**Consultation Response from KC,
Highways Development Management****2023/91486 110, Spen Lane, Gomersal, Cleckheaton, BD19 4AA****Formation of parking area and entrance wall with associated alterations****Date Responded: 16/08/2023.****Responding Officer: D. Stainsby****Responding Ref: K9-6SE/4**

This application is for the formation of parking area and entrance wall with associated alterations at 110, Spen Lane, Gomersal, Cleckheaton.

PROPOSED SITE PLAN 1:100

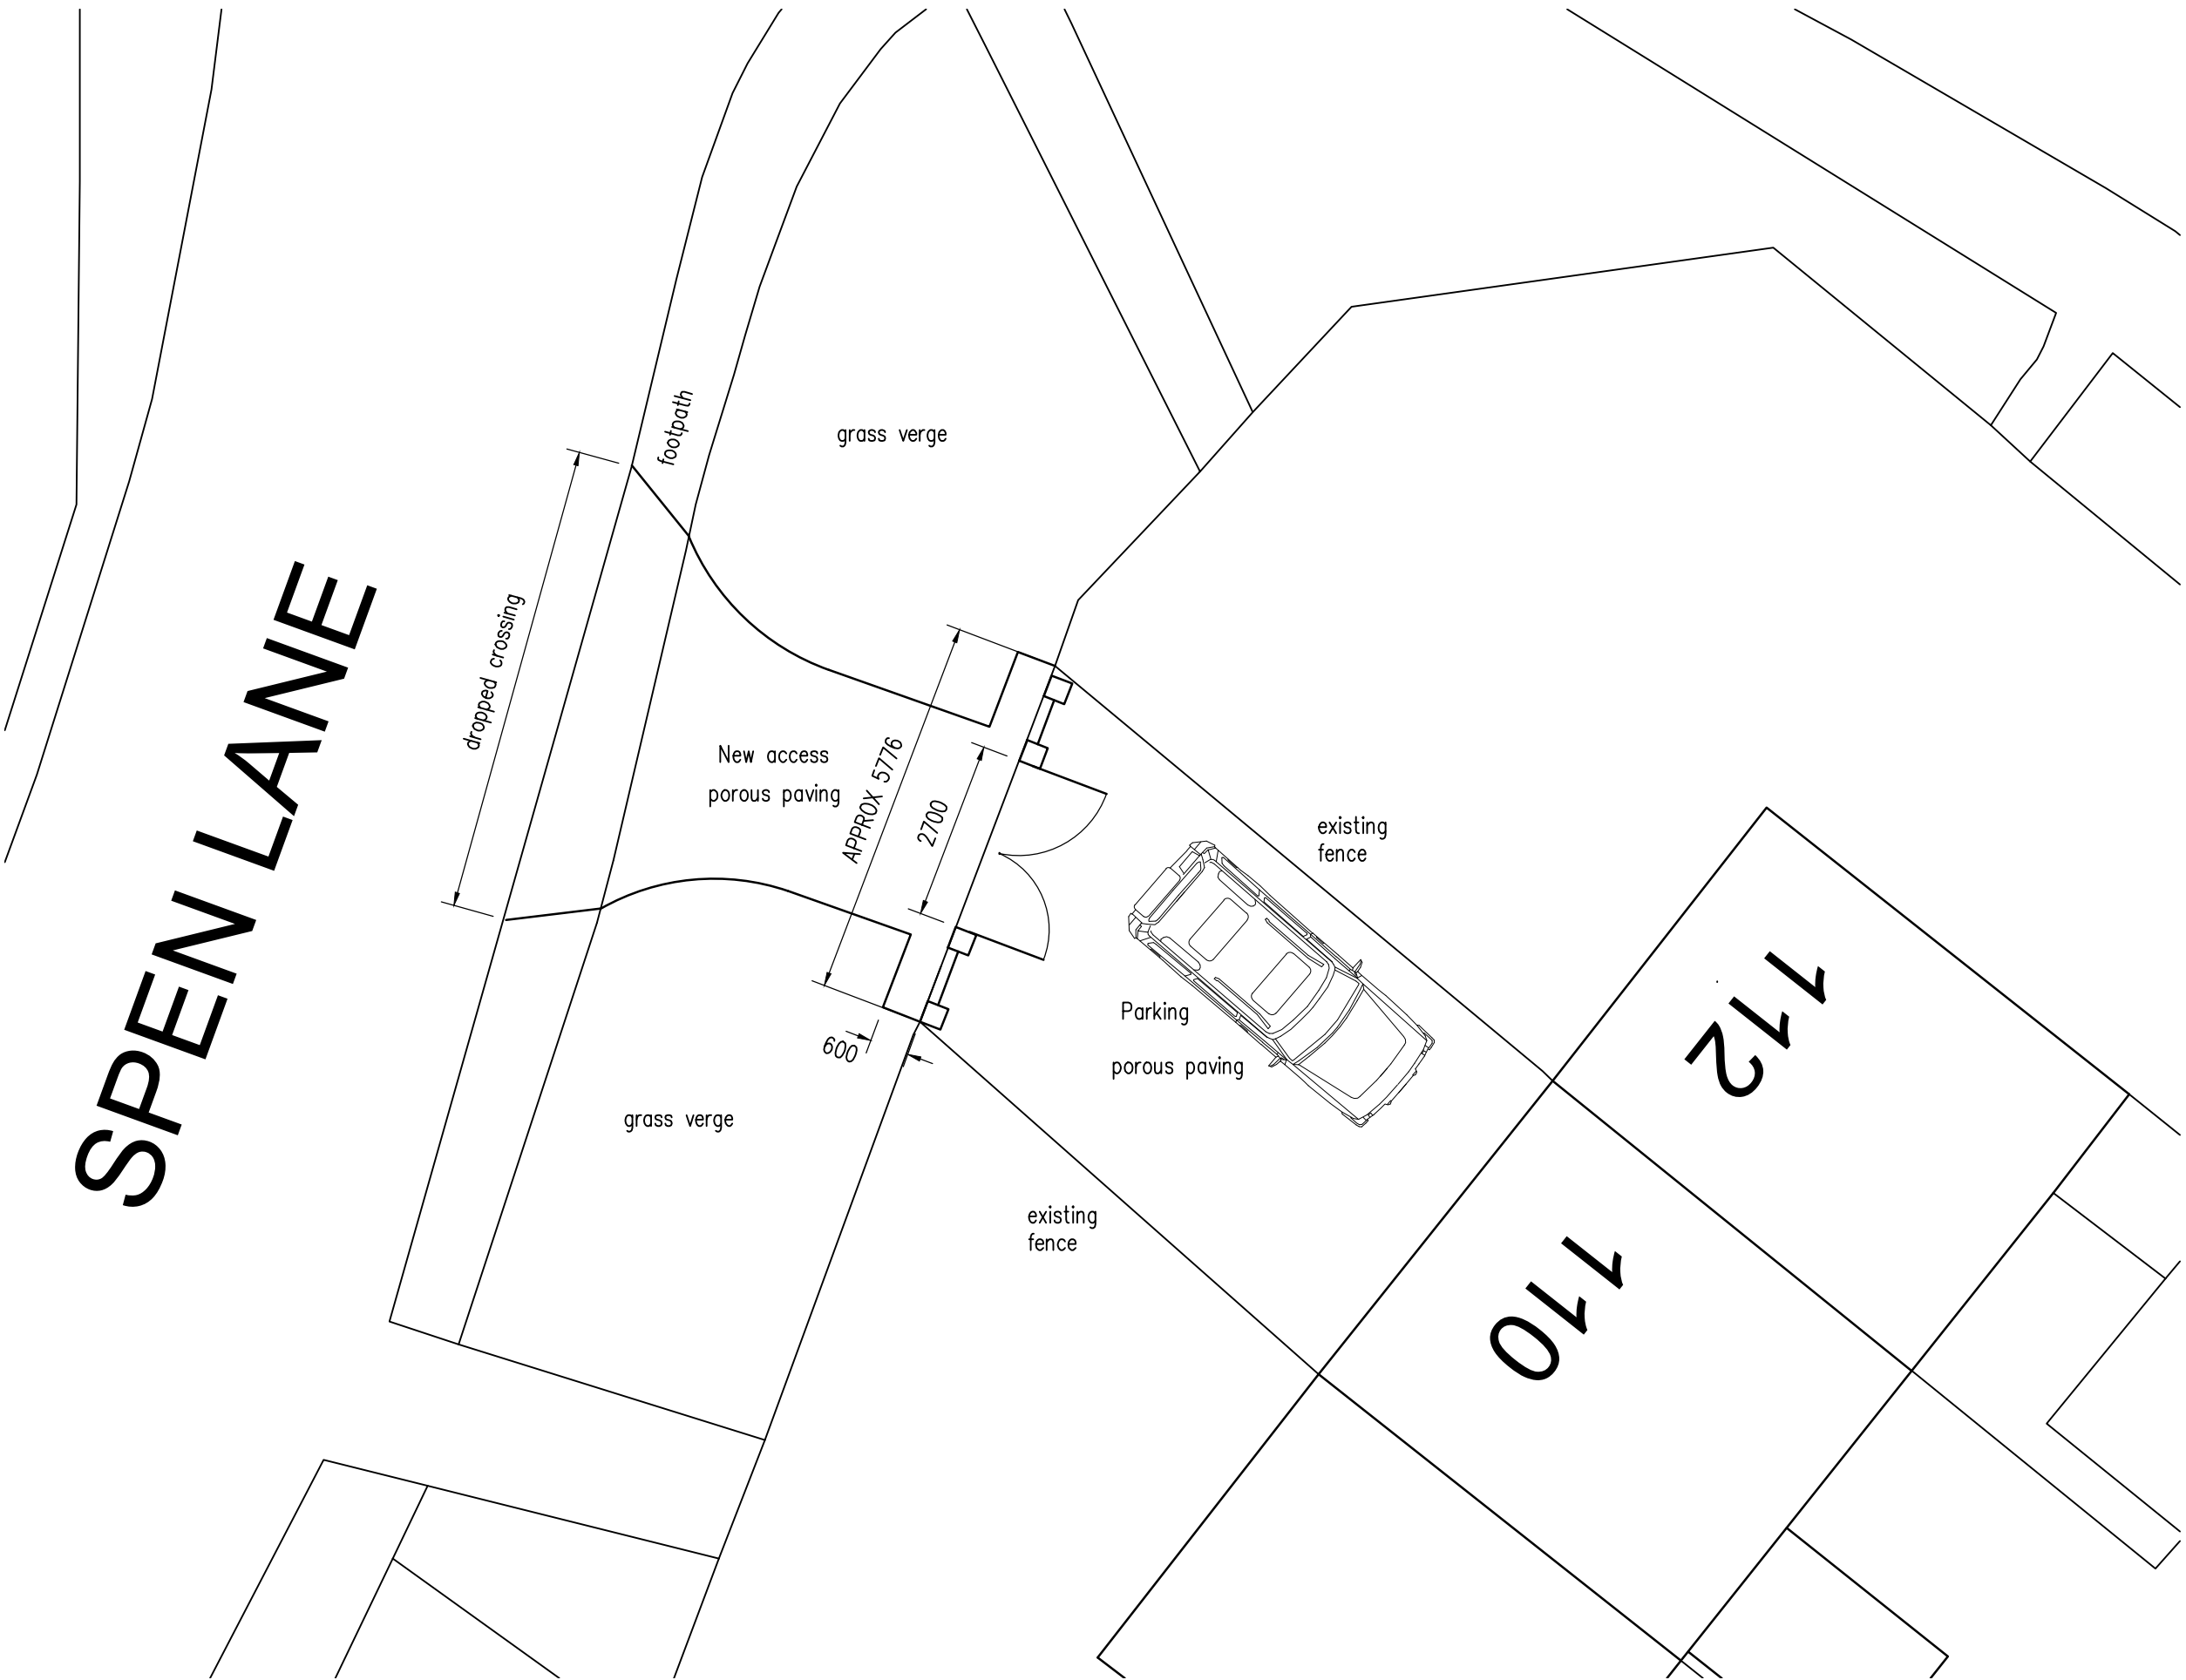
Currently the dwelling does not have any off-street parking and the proposals include the provision of two off street parking spaces which will remove parking from the local highway.

There is no on-site turning space provided for the vehicles and so reversing to park from A643 Spen Lane will be required.

Normally for any new access on to an A classified road we would require that turning was available to ensure that vehicles could enter and egress the site in forward gear.

However, in this instance the proposed off street parking spaces will negate the need to park on the highway in the vicinity of this location and there should be no additional highway safety concerns based around this.

The approved vehicle parking areas will need to be surfaced and drained in accordance with the Communities and Local Government; and Environment Agencies 'Guidance on the permeable surfacing of front gardens (**parking areas**)' published 13th May 2009 (ISBN 9781409804864) as amended or superseded.

A new vehicular crossing will need to be provided for the proposed driveway to the existing dwelling.

The changes to the access within the adopted highway fronting the property, to provide a dropped kerb, will need to be constructed under a section 184 agreement of the 1980 Highways Act (vehicle crossings over footways and verges). You are required to consult the Design Engineer (Kirklees Street Scene: 01484 221000) with regard to obtaining this permission and approval of the construction specification. Interference with the highway without such permission is an offence which could lead to prosecution.
